SYDNEY HARBOUR CASINO PROPERTIES

PROJECT STAR, STAR CITY

ACCESSIBILITY REVIEW

10th September 2008

Drawing Title			
EDWARD/ PYRMONT STREET ELEVATIONS			
CAD File	K:\2007\207061\Drawings\Plot	Drawn	CA/MD
Coordinator	AS	Scale	1:200@A1
Project Architect	AS	Date	27.6.2008
Project Director	JA	Rev	01
Cox Project No.	207061	Drawing Number	DA-3001
		North

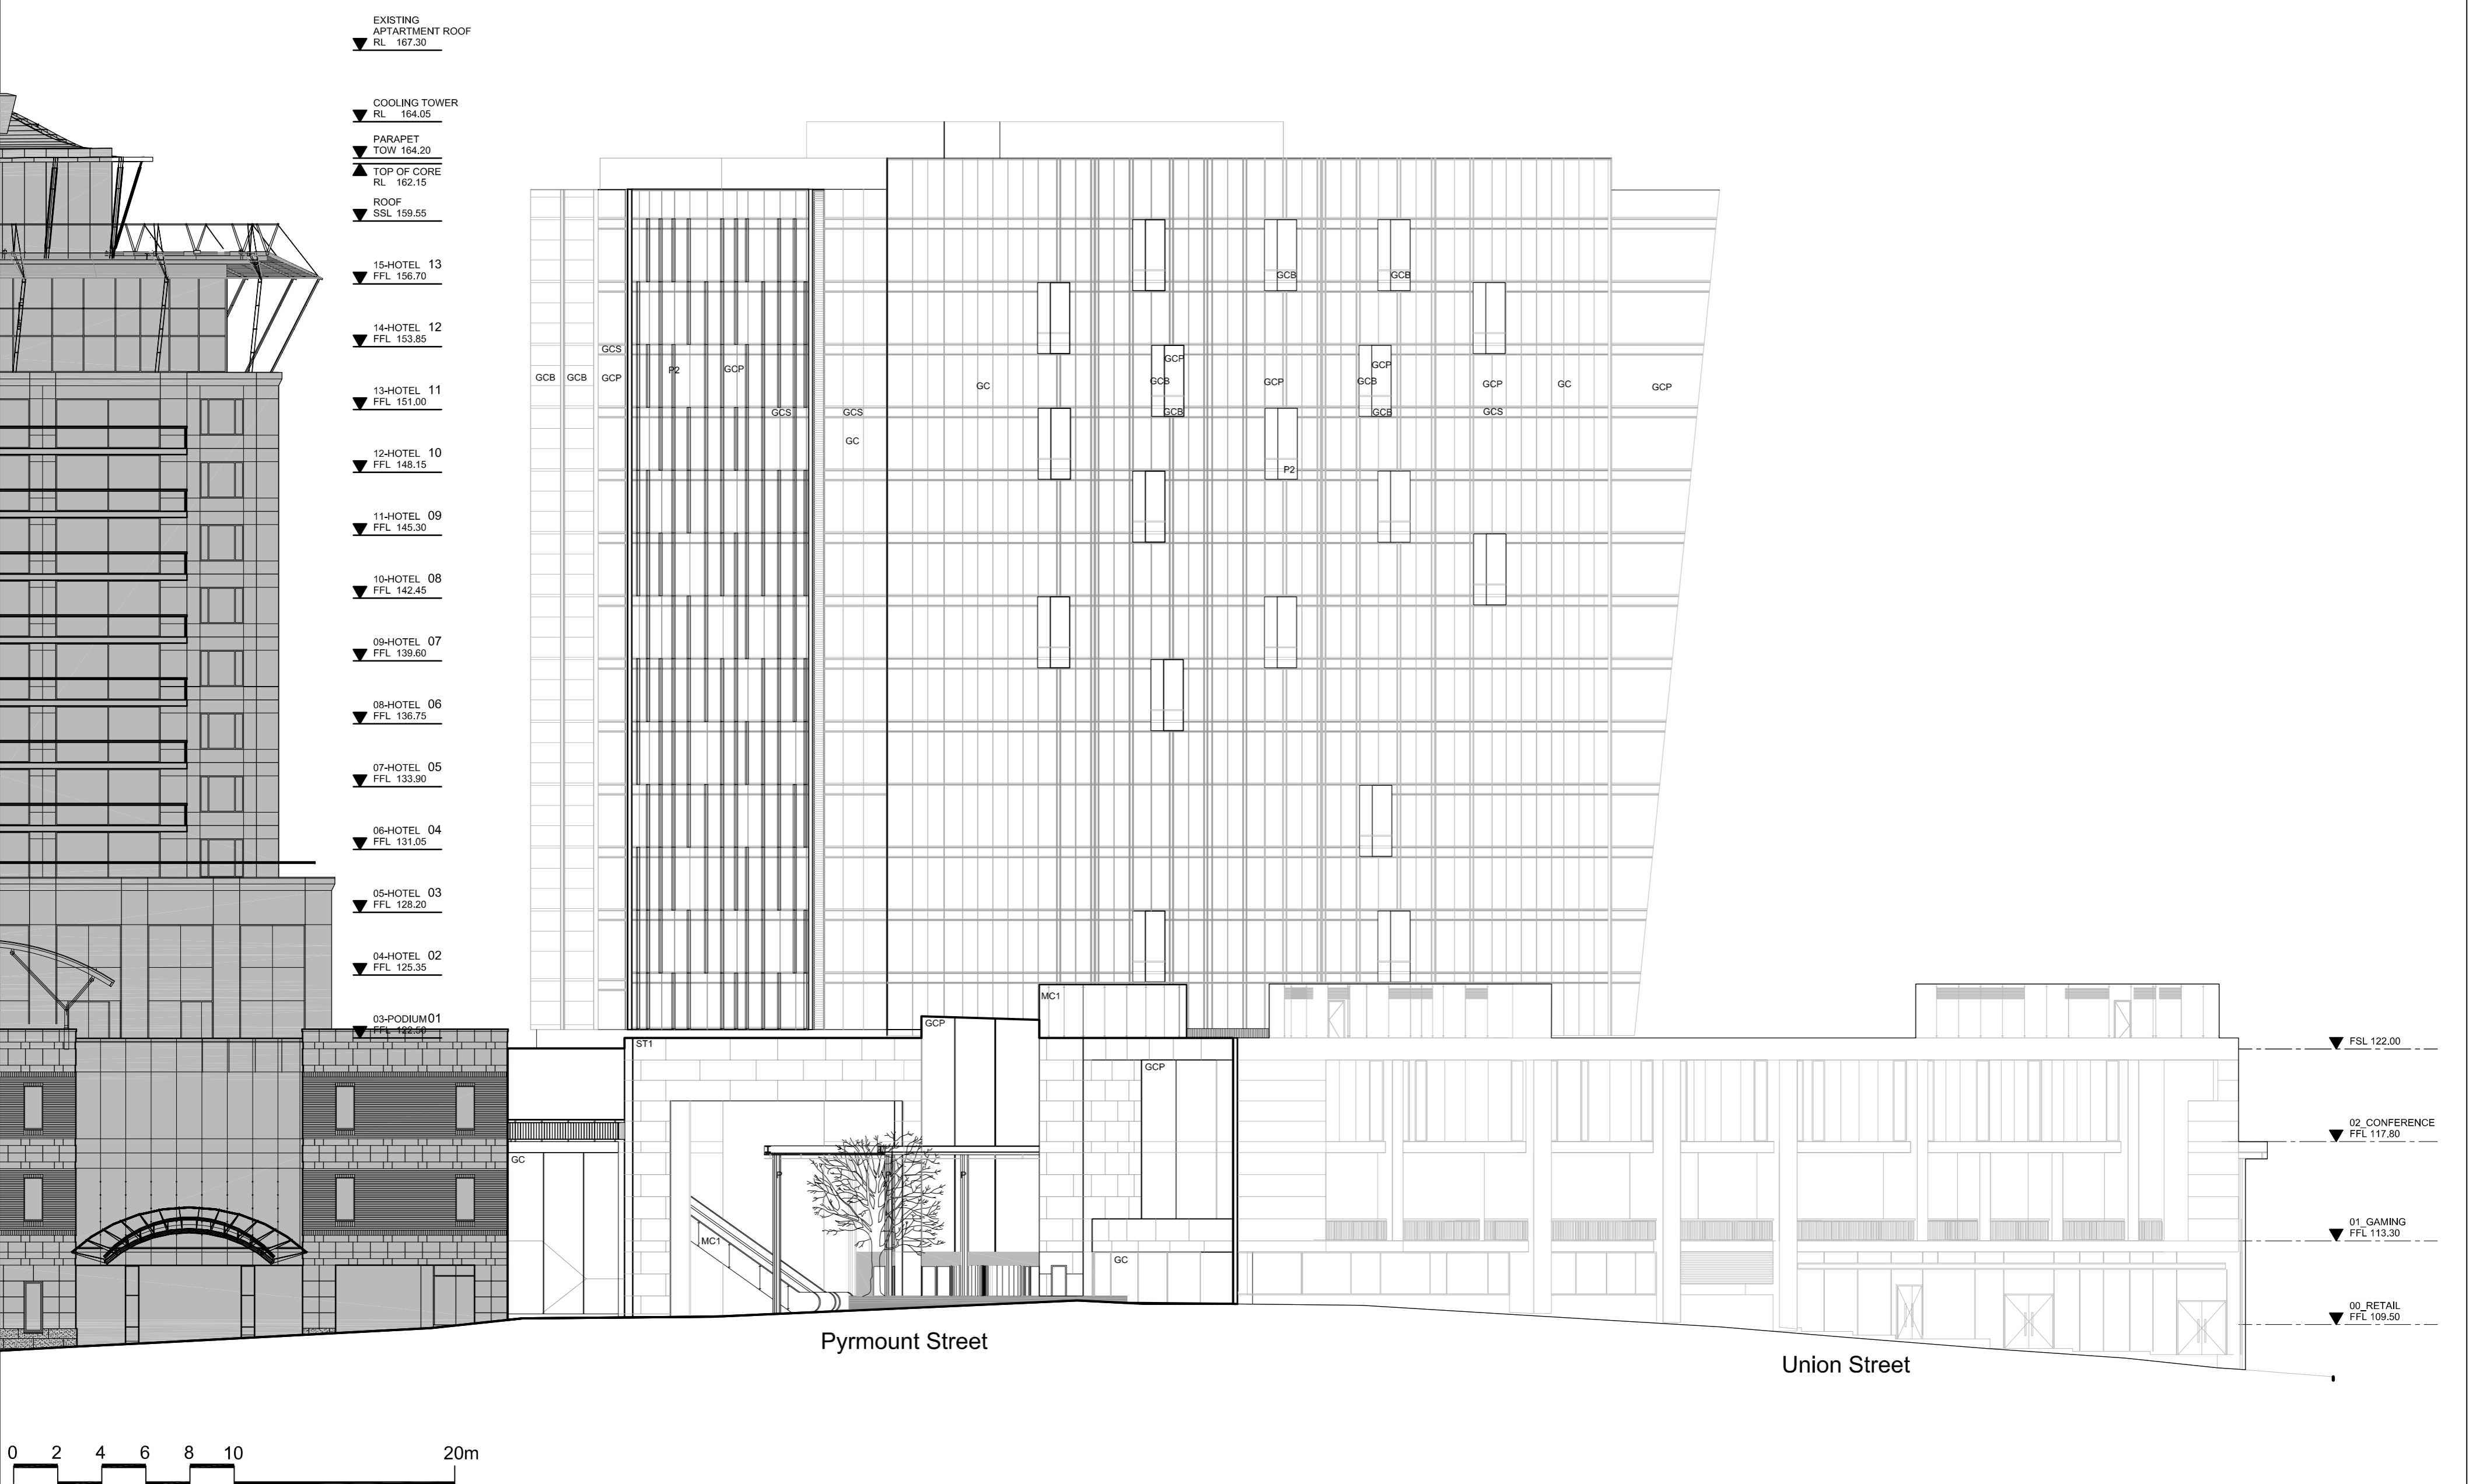
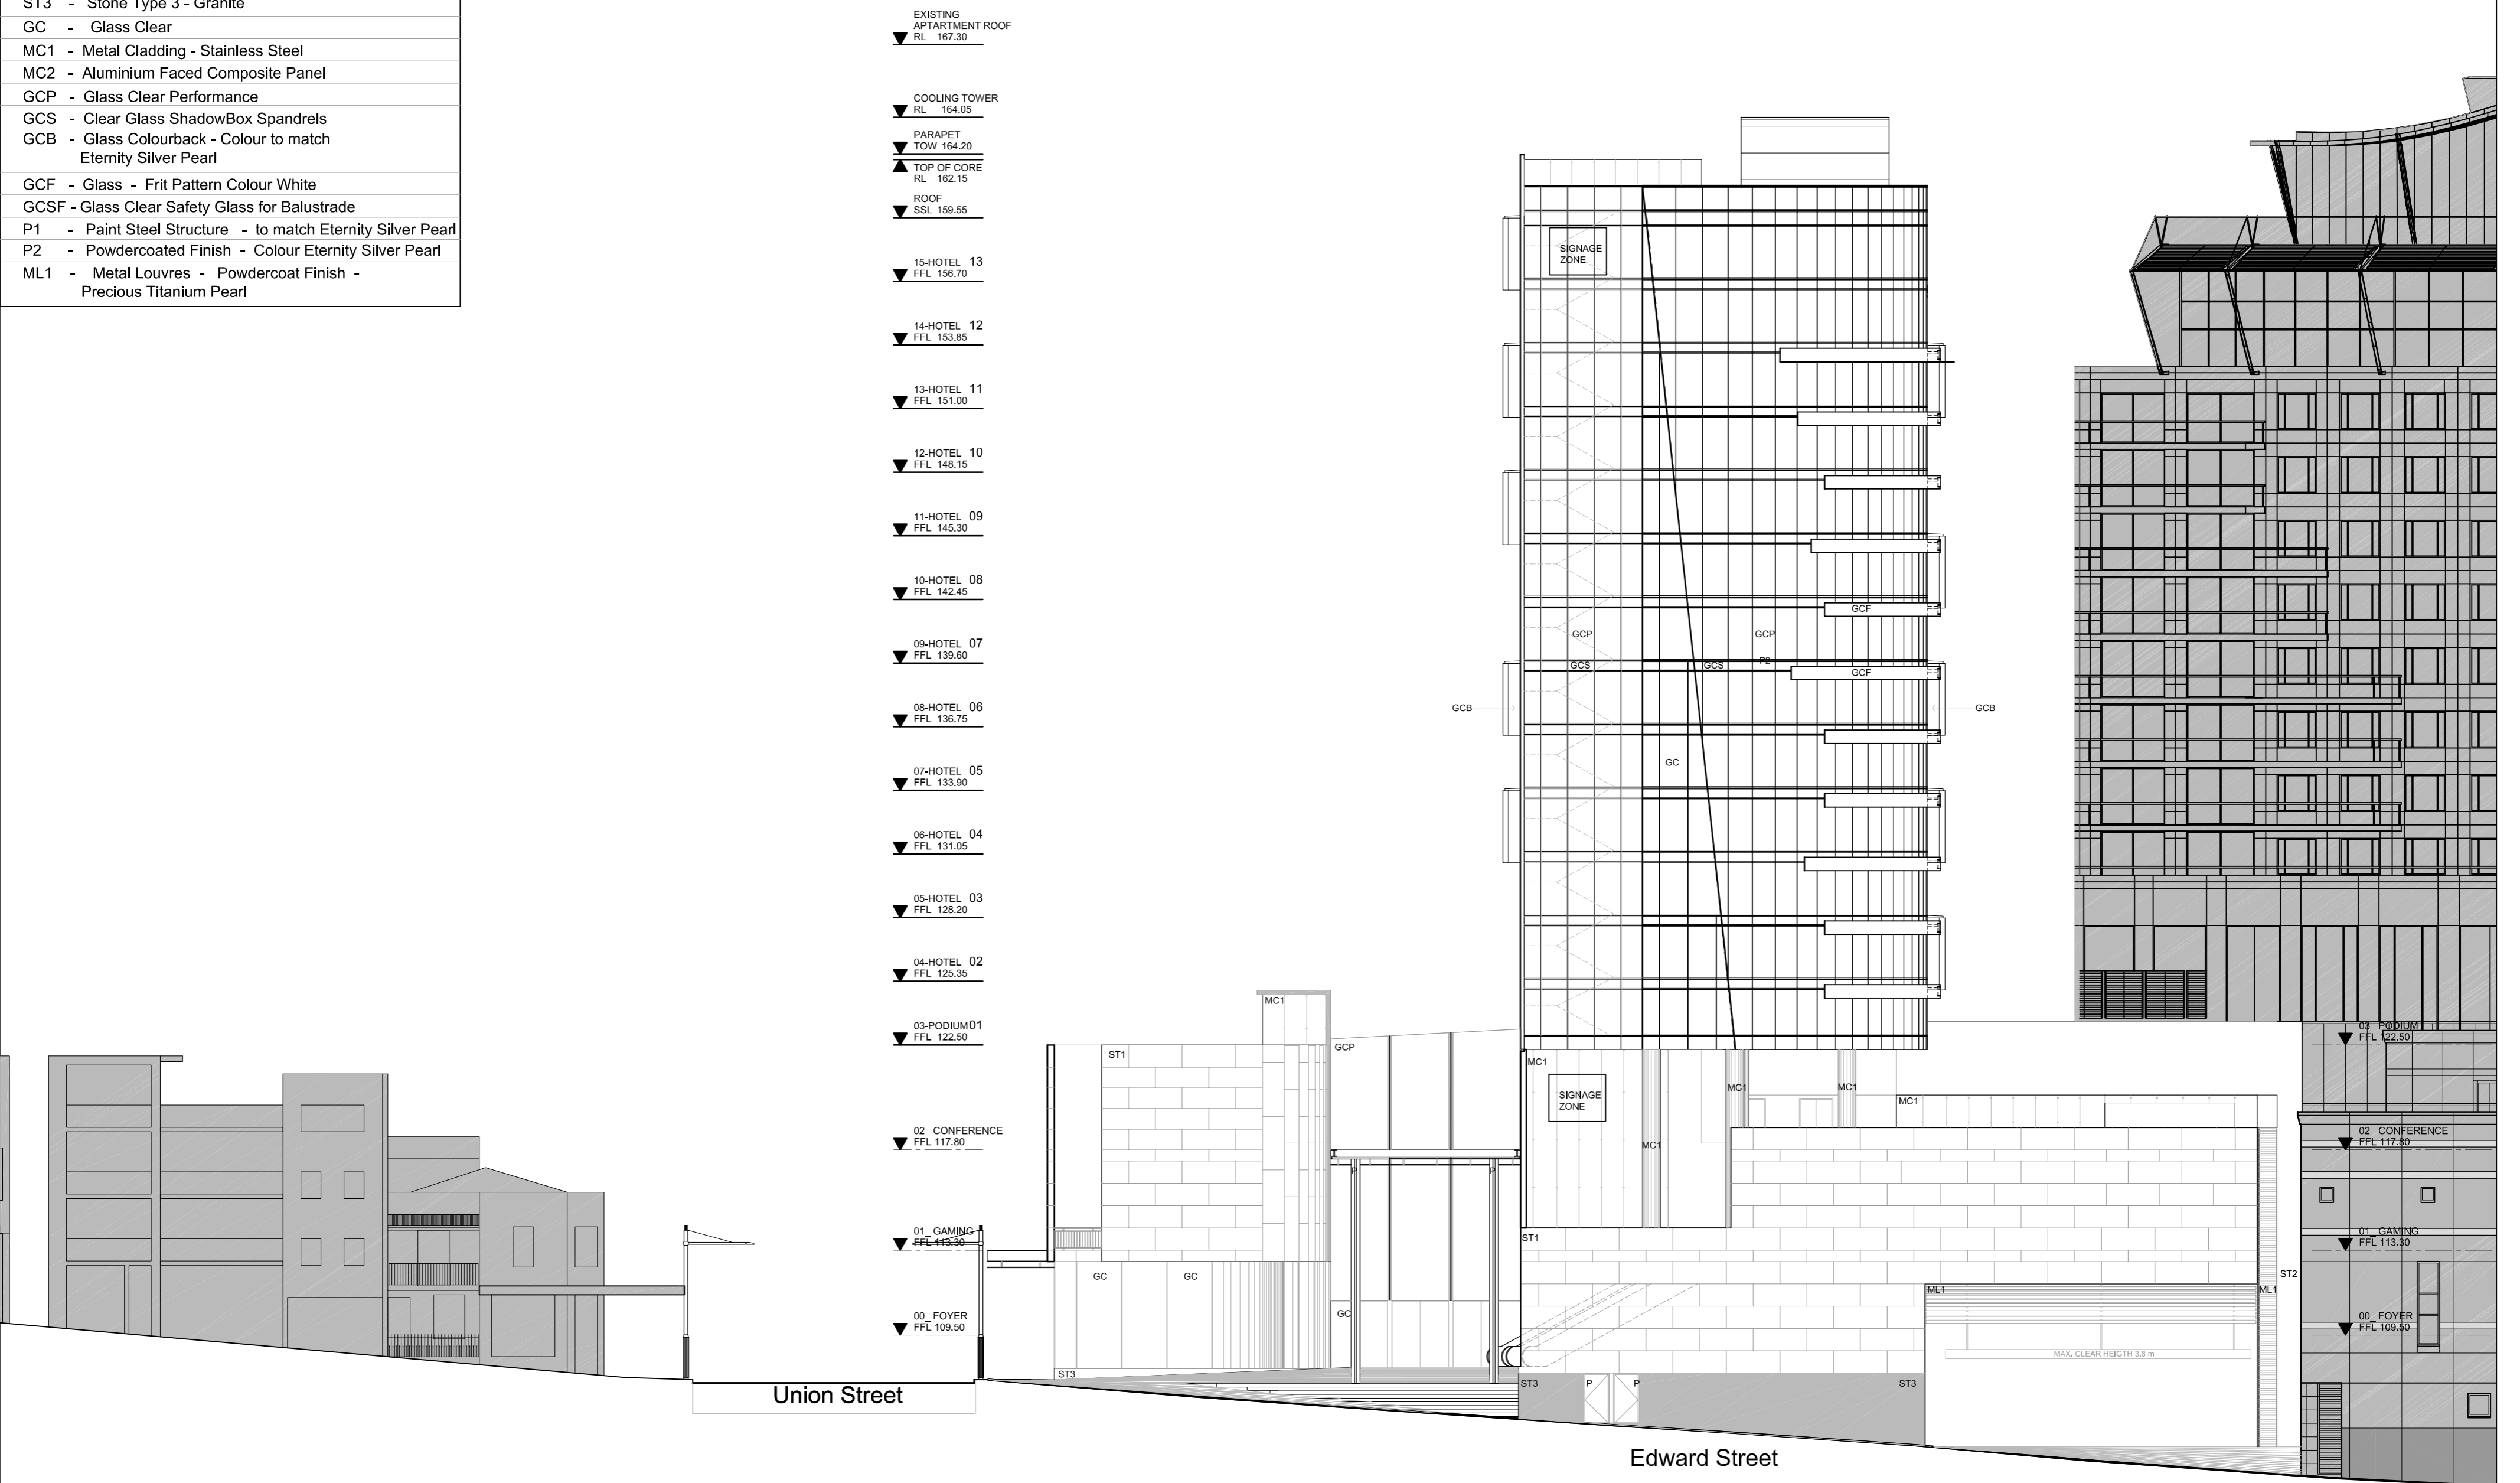
- (i) Ensure the platform lift has automatic doors to negate the poor latch side clearance of the lift doors
- (ii) Ensure the entry doors have 850mm clear width in accordance with AS1428.2. Consider power operation for ease of use for wheelchair users and luggage.

- (i) Ensure the entry doors have 850mm clear width in accordance with AS1428.2. Consider power operation for ease of use for wheelchair users and luggage.
